Re: Modification to SITA Advanced Waste Treatment Facility, Kemps Creek

I refer to the 'Modification Assessment Report' prepared by AECOM for SITA Australia Pty Ltd and Consultation Draft dated January 2014 produced by the Department of Planning & Infrastructure "the Department") for the proposed Modification of Project Approval (06_0185) submitted to the Environment Protection Authority (EPA) on 8 January 2014.

I:\Groups\ENV\GIS\602 Projects\60250100 Kempers Creek\FIGURES\Modification\60250100 FB-1 Proposed Modifications to the Existing SAWT Facility 02.12.2013 TO Rev C

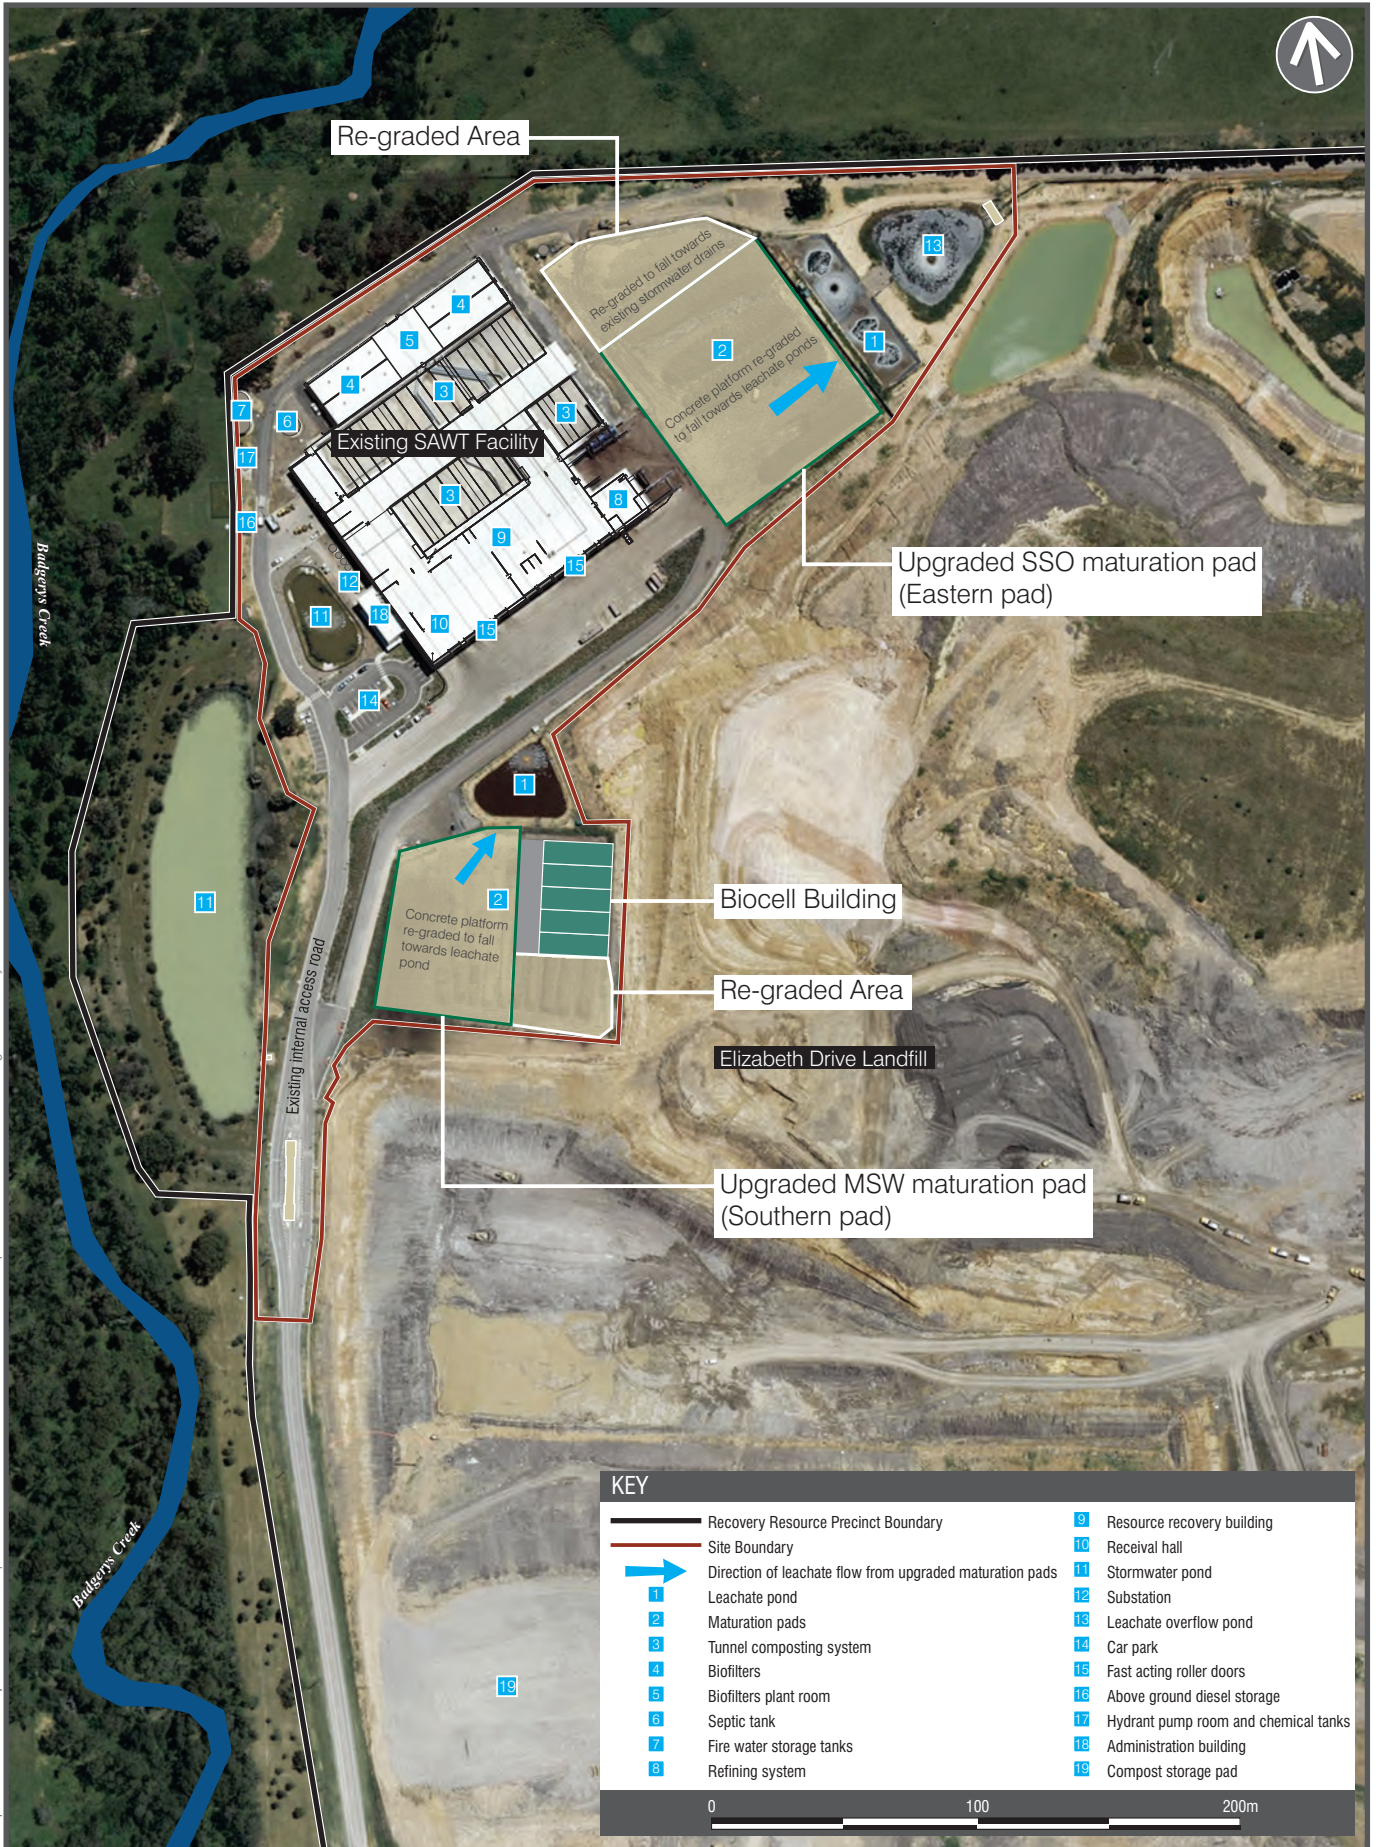
This condition should be updated to reflect the upgrade to a concrete hardstand. Therefore the EPA recommends that 'or concrete hardstand' be added to the Condition. The EPA also recommends the following conditions.

"The leachate barrier referred to in Condition 18 must be graded to drain to a leachate collection system".

"Water which contacts compost products or organic outputs in the outdoor areas must be managed as leachate".
